Engineers Comments Regarding Surface Water Drainage

Application Reference:	Y/71/25/DOC	Reviewer Reference:	ADC/EXT4
Planning Officer:	Simon Davis	Date of Review:	17/03/2026
Site Name:	Land at Stakers Farm North End Road Yapton		
Application Description:	Approval of details reserved by condition imposed under Y/44/17/OUT relating to condition 18-updated copy of management manual for SuDS system.		
Assessment Number:	2 of 2

Application Reference: Y/71/25/DOC Site Name: Land at Stakers Farm North End Road Yapton	Initial Issue Date: 29/12/2025 Issue Date: 17/03/2026 Reviewer Reference: ADC/EXT4
--	--

TYPICAL INSPECTION CHAMBER - TYPE 4
(FLEXIBLE MATERIAL DETAIL)
MAXIMUM DEPTH FROM COVER LEVEL TO INVERT OF PIPE 0.6m, NON-ENTRY

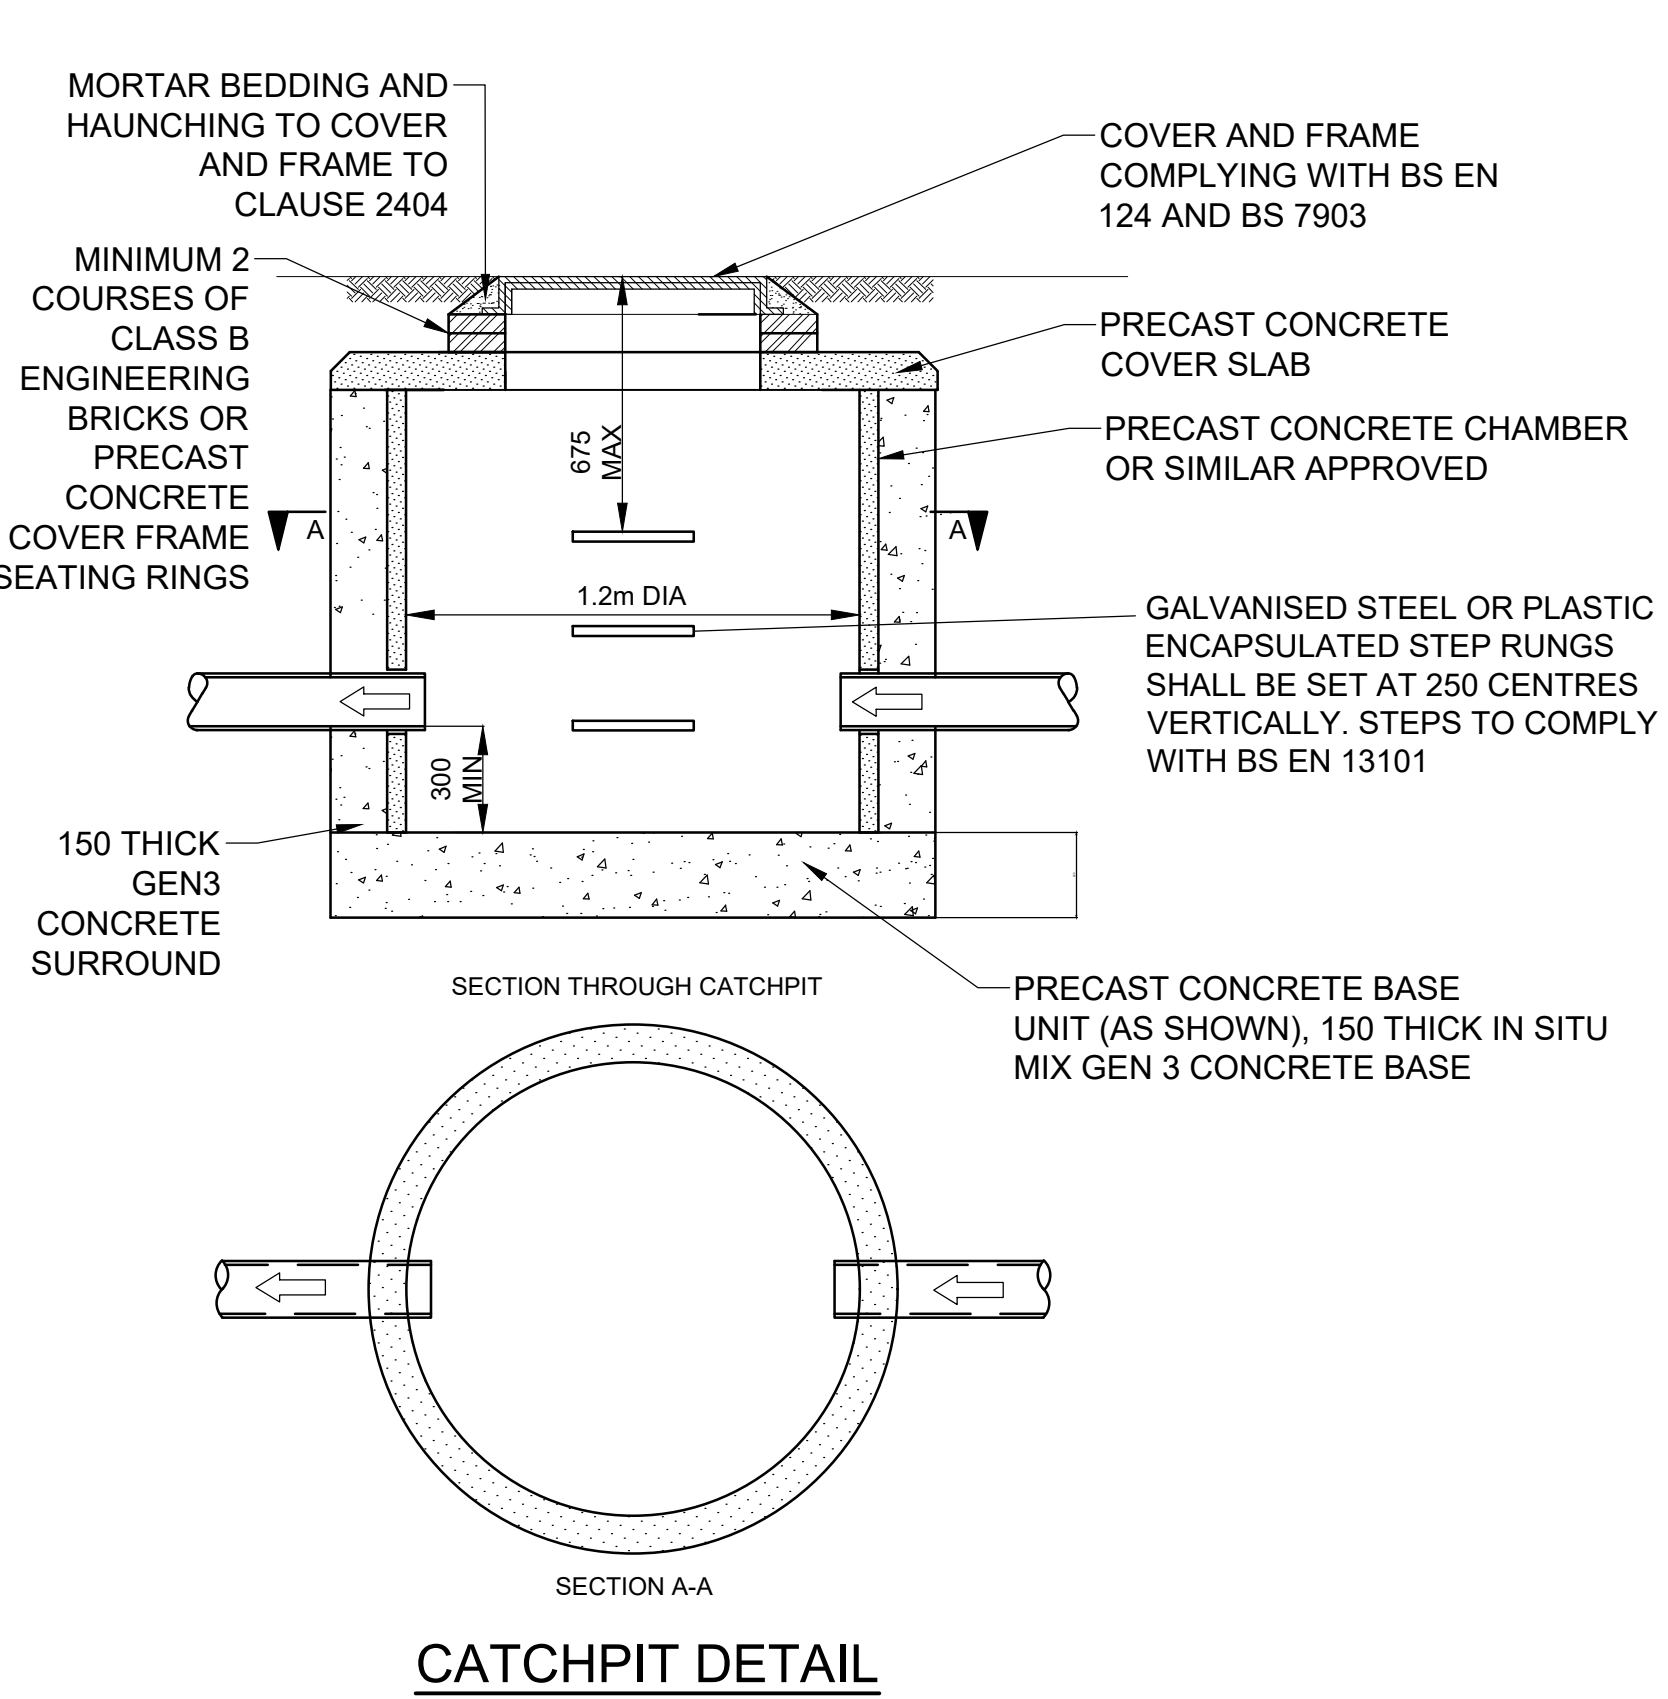
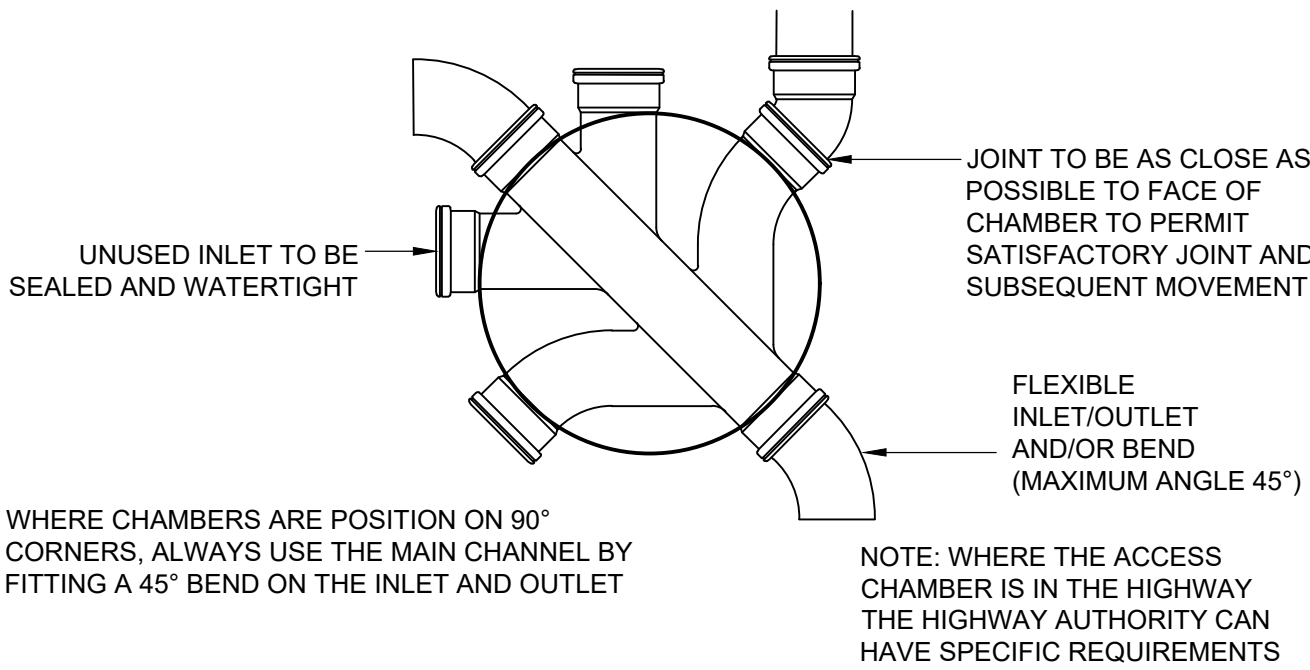
2.	The maintenance plan only appears to include the asbuilt survey, the full set of approved design drawings must be included with the Maintenance and Management Plan	Full set of approved design drawings included.	Only the drainage layout plans appear to have been included in the updated Maintenance Plan report. All drawings including drainage

construction details need to be included		
3.	Please provide a plan showing maintenance responsibility should be included in the report	Additional drawing YAP-130-090 provided that differentiates the responsibility between management company and respective householders.	Thank you for providing this but please add a key to this drawing to identify which the red colour and blue colour drainage relates to please
